East Pye Solar
Statement of Common Ground: Norfolk Wildlife
Trust

Revision 1
October 2026

Planning Inspectorate Reference: EN0110014

Document Reference: EXAM/9.7

Figure 8.3 - Non-Statutory Designated Sites within 2km
 Sheet 3 of 6
 Revision A

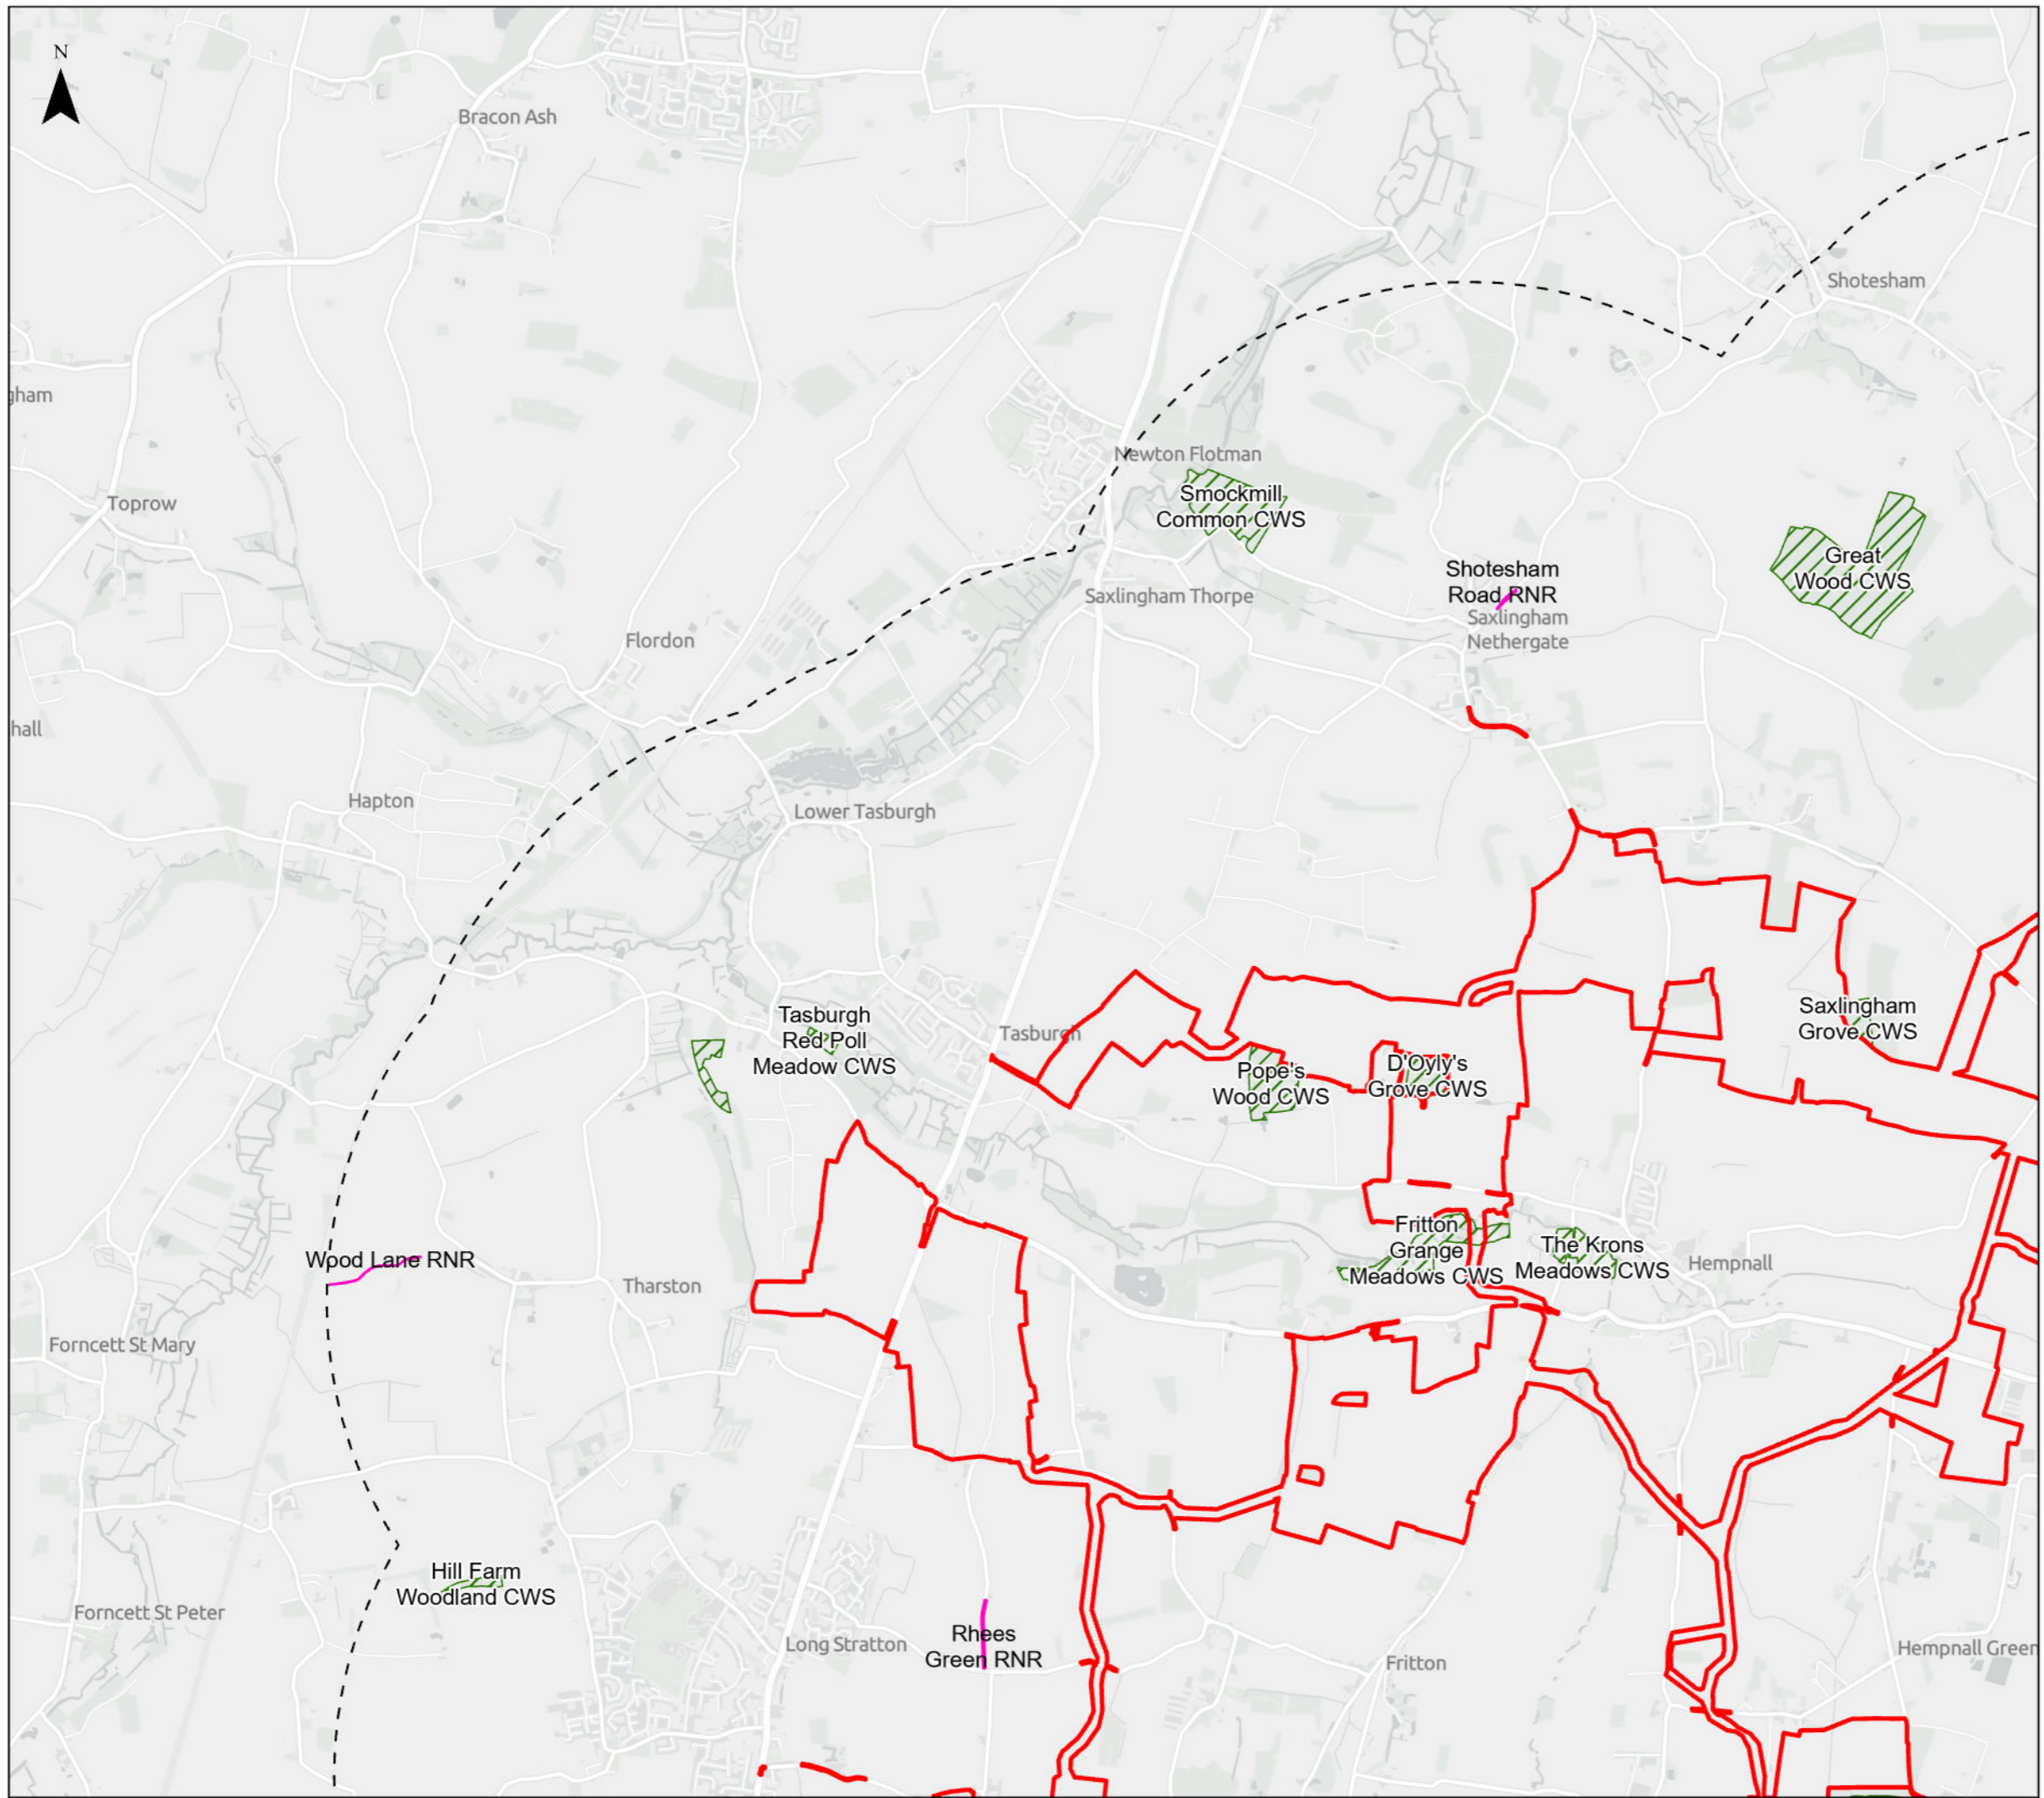
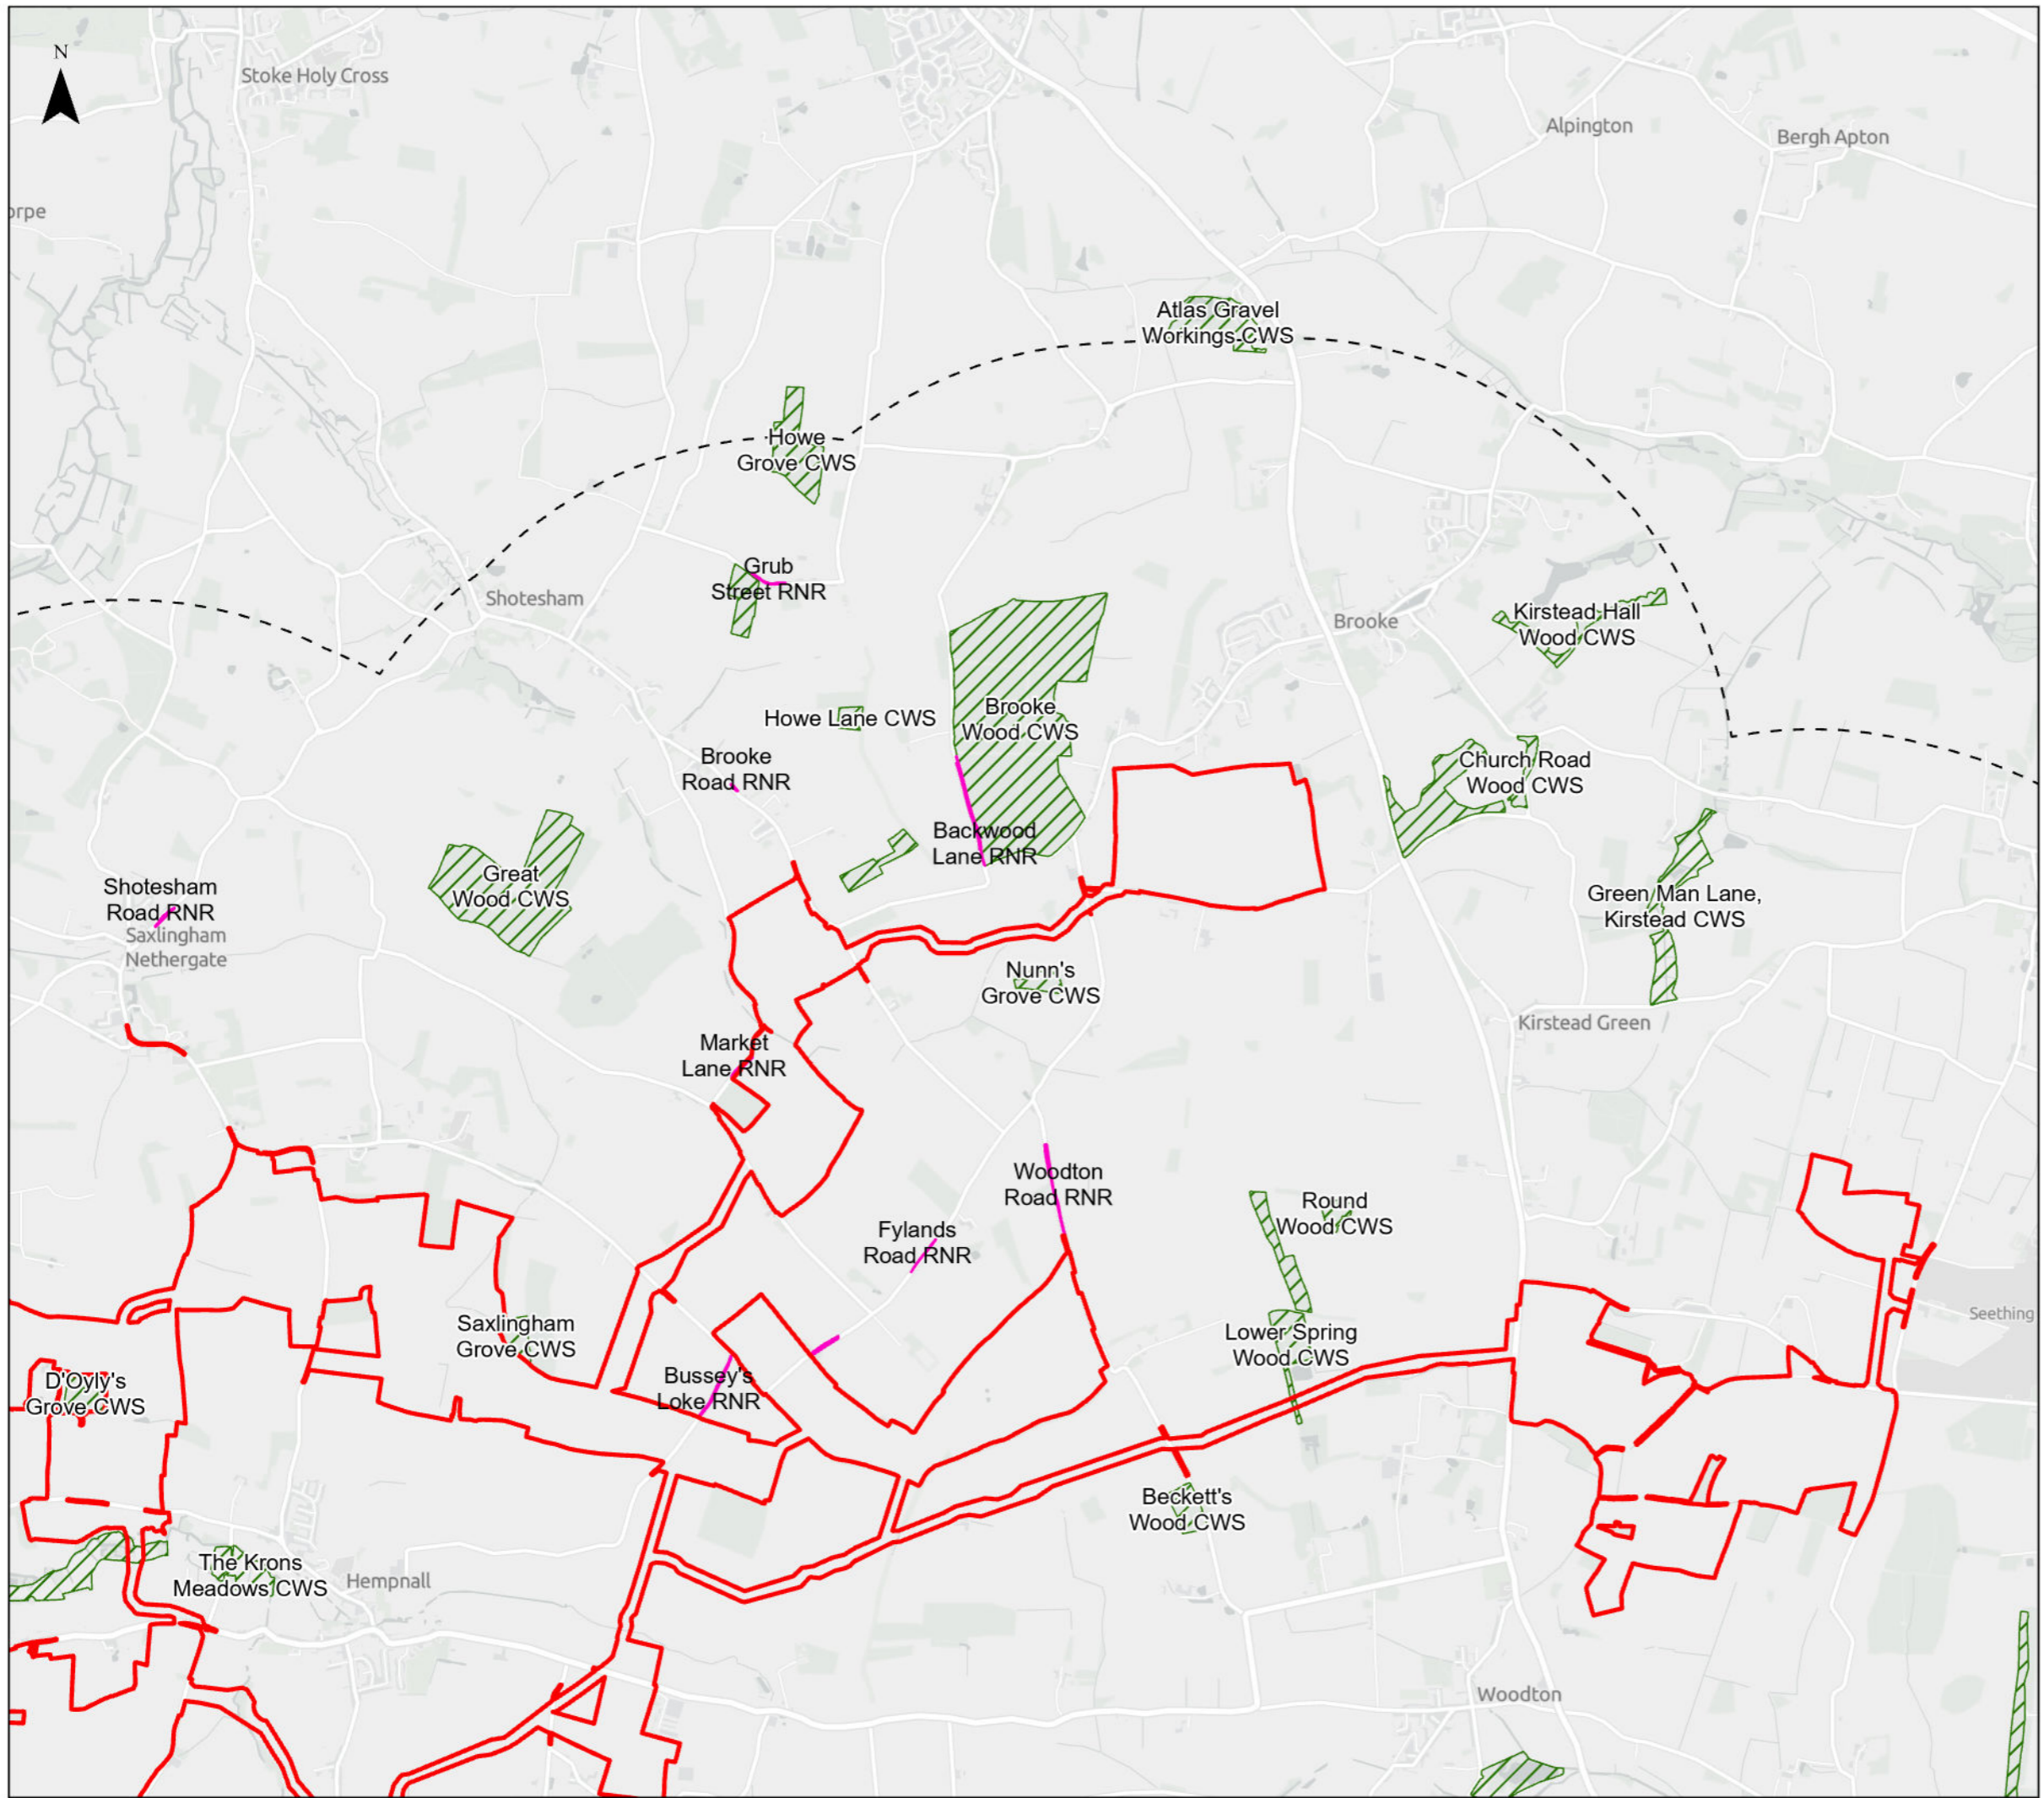
NWT EB - 4	Impacts on County Wildlife Sites and Roadside Nature Reserves	ES Volume 1, Chapter 8 – Ecology and Biodiversity [APP-044]	The Order Limits include parts of two County Wildlife Sites (CWSs) Lower Spring Wood CWS, and Fritton Grange Meadows CWS, and are adjacent/in the immediate vicinity of several others.	The Applicant is satisfied that the assessment set out between paragraphs 8.9.47 and 8.9.109 of ES Volume 1, Chapter 8 - Ecology and Biodiversity [APP-044] , has adequately assessed impacts to	Under discussion

The Order Limits also include or adjoin several Roadside Nature Reserves (RNRs), including Bussey's Loke, Market Lane and Parker's Lane. While the applicant proposes to cross both CWSs using Horizontal Directional Drilling (HDD), critical details remain unresolved. The Outline Construction Environmental Management Plan (oCEMP) confirms that the precise locations of HDD entry and exit points will only be determined at the detailed design stage.	County Wildlife Sites (CWSs) and Roadside Nature Reserves (RNRs). The Scheme has designed out impacts to these sensitive sites through run-off control, pollution prevention and dust control during construction which will be secured by the Outline CEMP [APP-196]. Stand-off distances of 30m from the CWSs and the adoption of Horizontal Directional Drilling (HDD) will mitigate impacts. As per Section 4.4 of the Outline Cable Route Construction Statement [APP-216] the technology used for the HDD will be determined by feasibility studies carried out at each crossing during the detailed design stage and in accordance with a method statement. The embedded design principles adopted and detailed within the Design Principles, Parameters and Commitments [APP-213] have been applied to protect CWS, and commit to specific CWS avoidance areas; this will include HDD entry and exit points.
